WEST SUSSEX COUNTY COUNCIL CONSULTATION

TO:	Arun District Council FAO: Mr S Davis
FROM:	Highways, WSCC
DATE:	23/11/2018
LOCATION:	Land North of Sunnyside Cottage, Yapton Road, Barnham
SUBJECT:	BN/48/18/PL Removal of existing building and erection of two new dwellings .
DATE OF SITE VISIT:	
RECOMMENDATION:	☒ Advice ☐ Objection ☐ Modification ☐ No Objection ☐ More Information ☐ Refusal
S106 CONTRIBUTION TOTAL:	£N/A

Block Plan

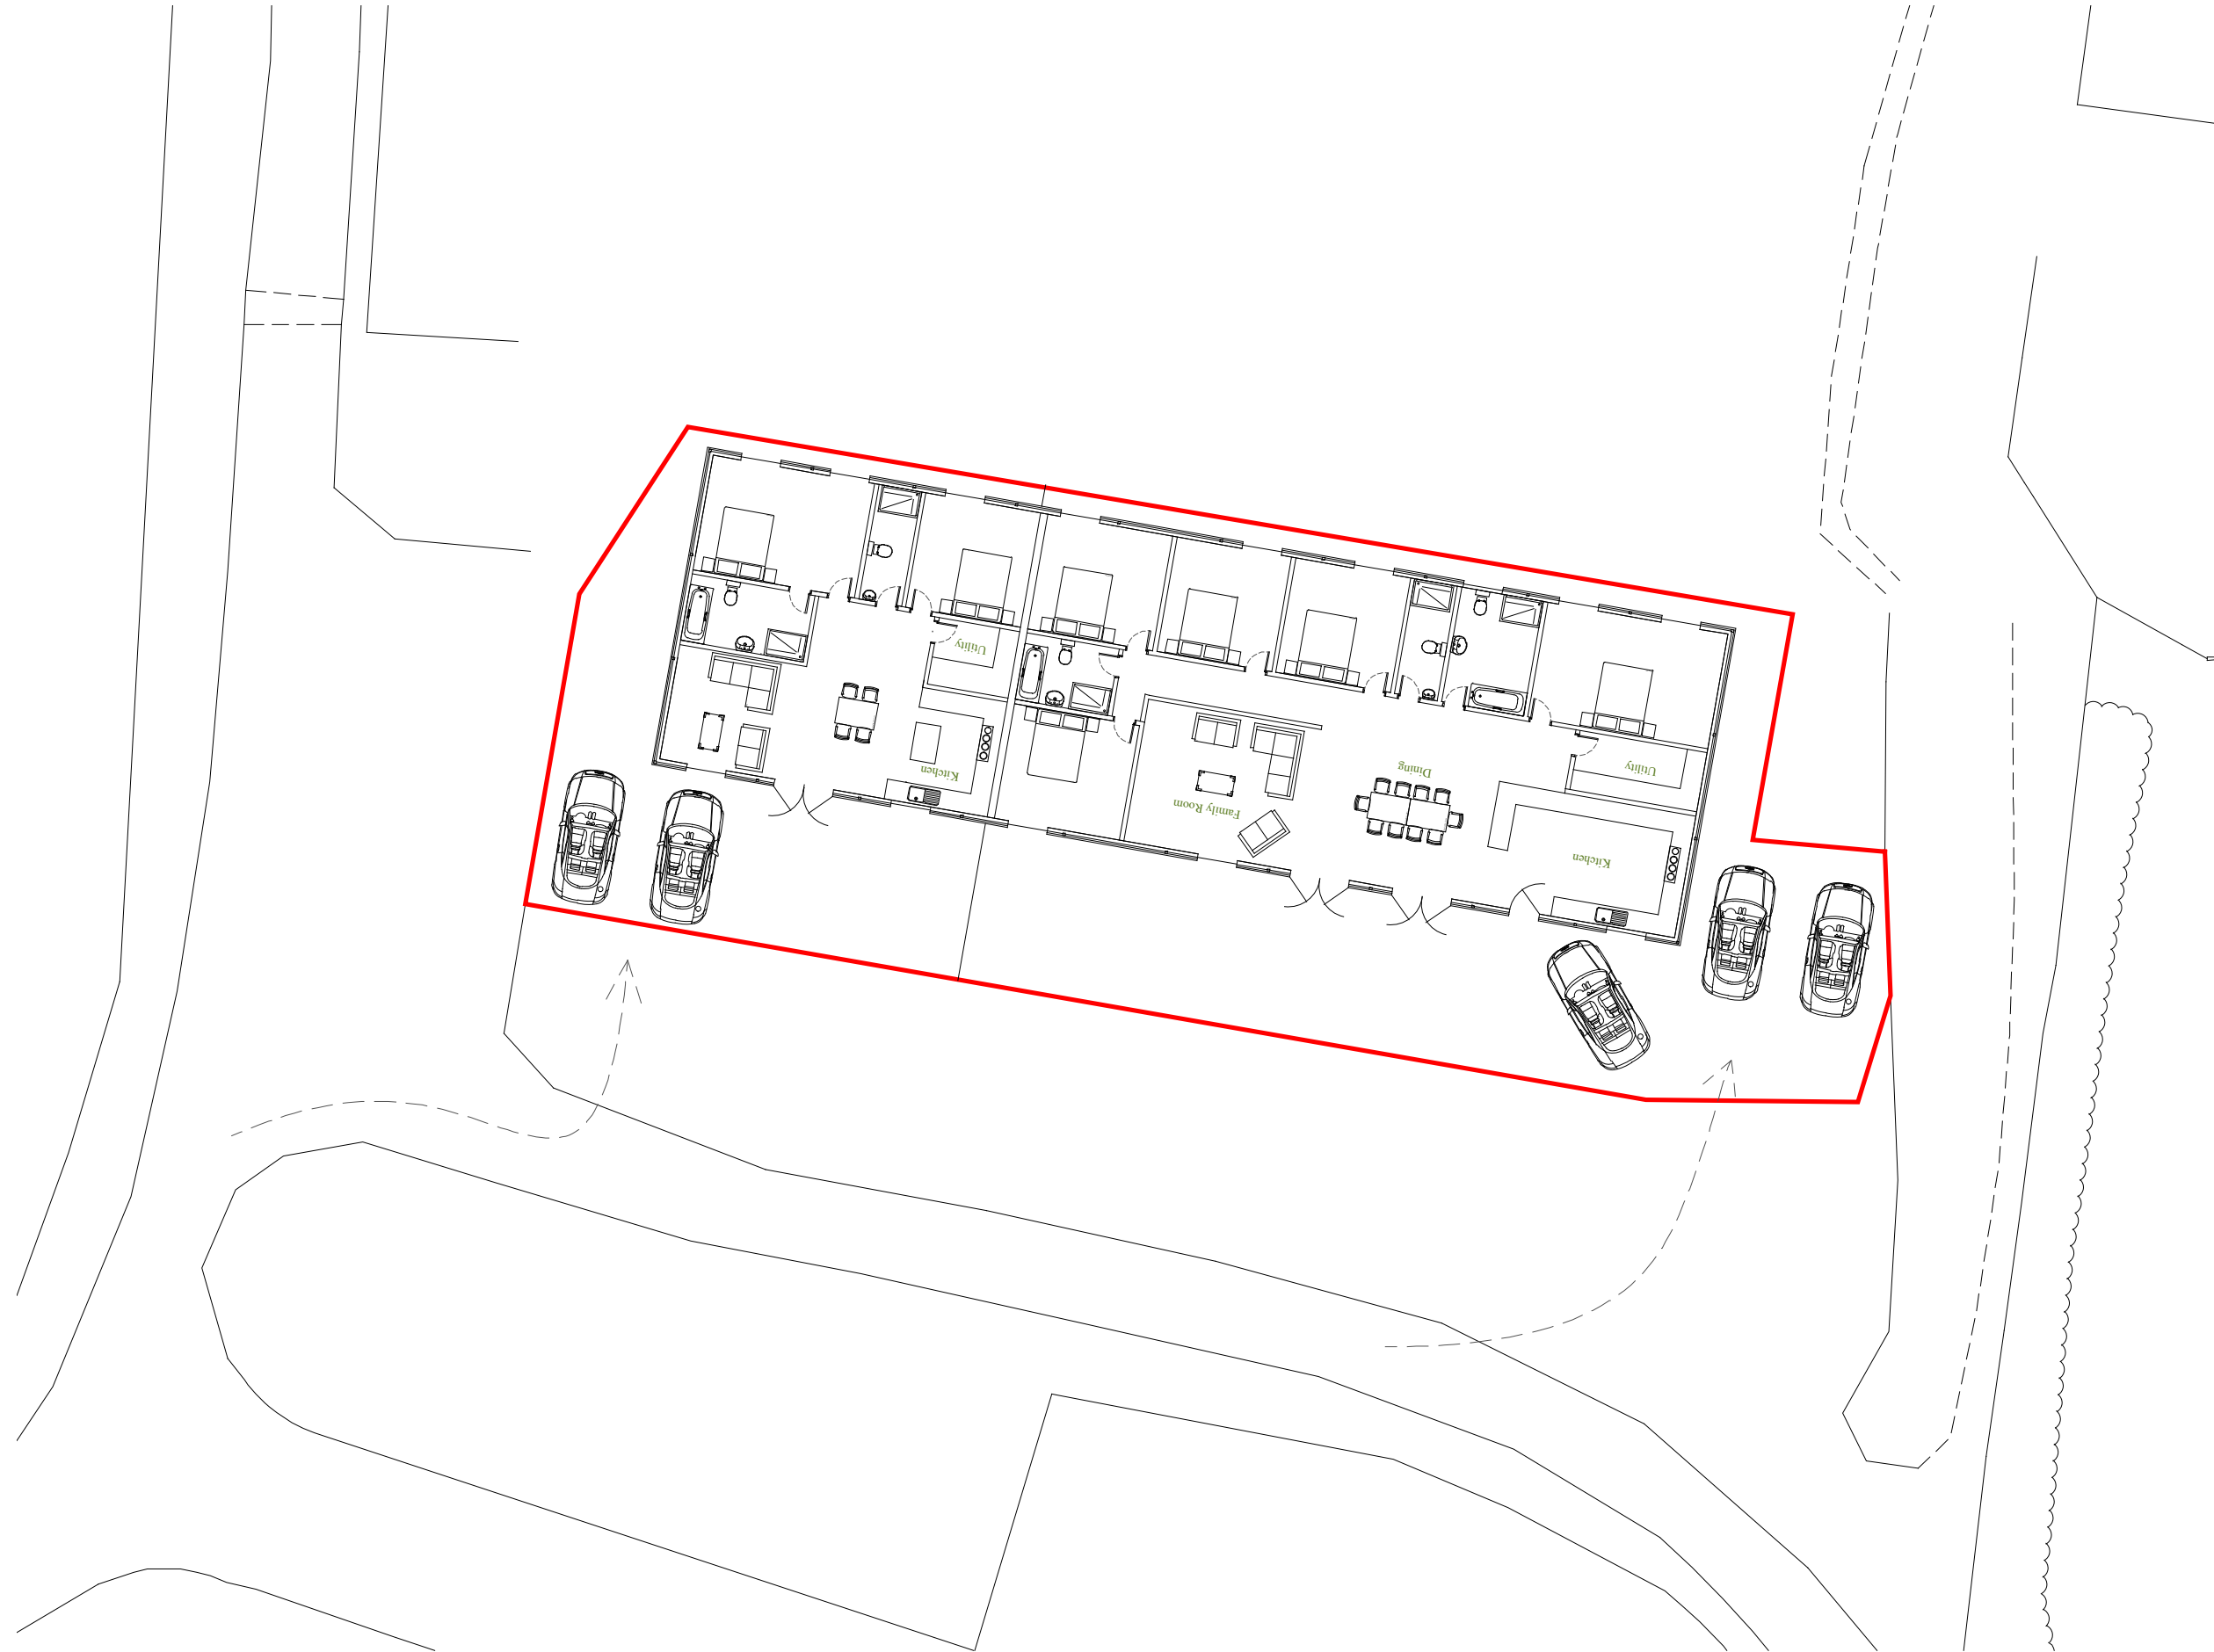
Vehicular parking spaces have been demonstrated by the applicant, 5 parking spaces are proposed, although there appears space for further parking within the red edge curtilage of the site. Overflow parking would not be anticipated to occur on the Publicly Maintained Highway.

No part of the development shall be first occupied until the car parking has been constructed in accordance with the approved site plan. These spaces shall thereafter be retained at all times for their designated purpose.
